Consultation Response from: KC Environmental Health (Pollution & Noise Control)

2025/93394 - Rowley Mills, Penistone Road, Fenay Bridge, Huddersfield, HD8 0LE

Erection of 3 storey front extension and 2 storey rear extension of Rowley Mills with associated car park amendments, ancillary structures and landscaping; first floor roof extensions, car park amendments and landscaping at International House with new access infrastructure and pedestrian crossing facility

**Responding Ref:
WK202540791**

**FIGURE 1 – SITE AERIAL VIEW AND APPROXIMATE MEASUREMENT LOCATIONS**

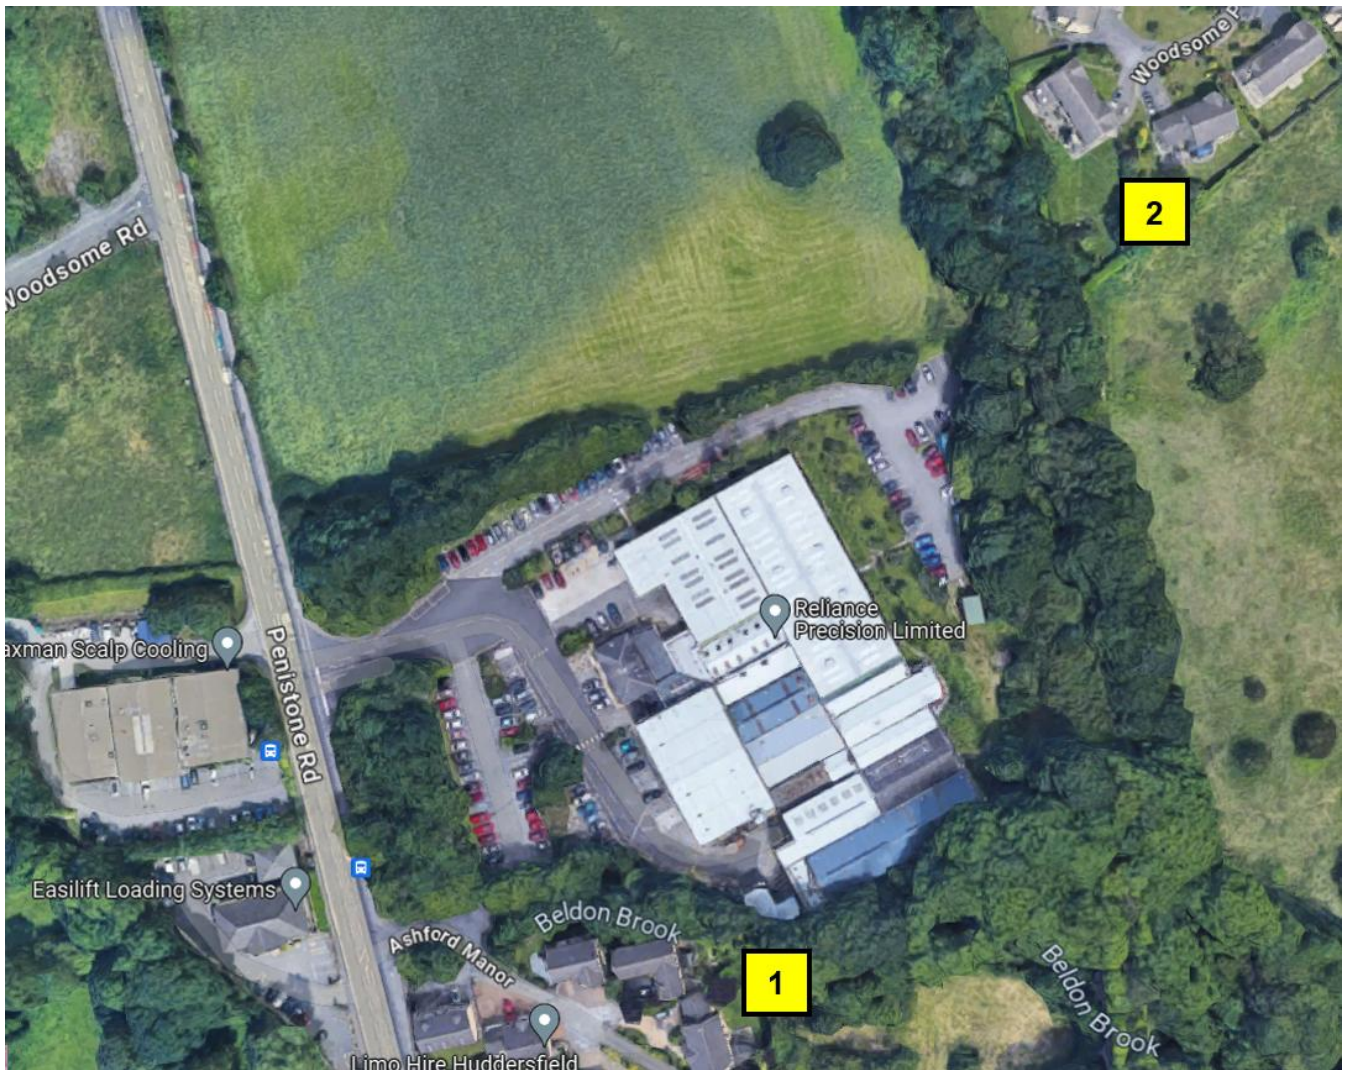
A Noise Assessment has been submitted authored by Blue Tree Acoustics dated 05 December 2025 Ref 03780-130202. It details the proposals for both sites in paras 1.6 and 1.8, identifying the nearest noise sensitive receptors as the residential properties in Ashford Manor and Woodsome Park as shown in figure 1. The report determines the works at International House will be similar to the existing use and therefore of a low impact and so focusses on the Rowley Mills site.
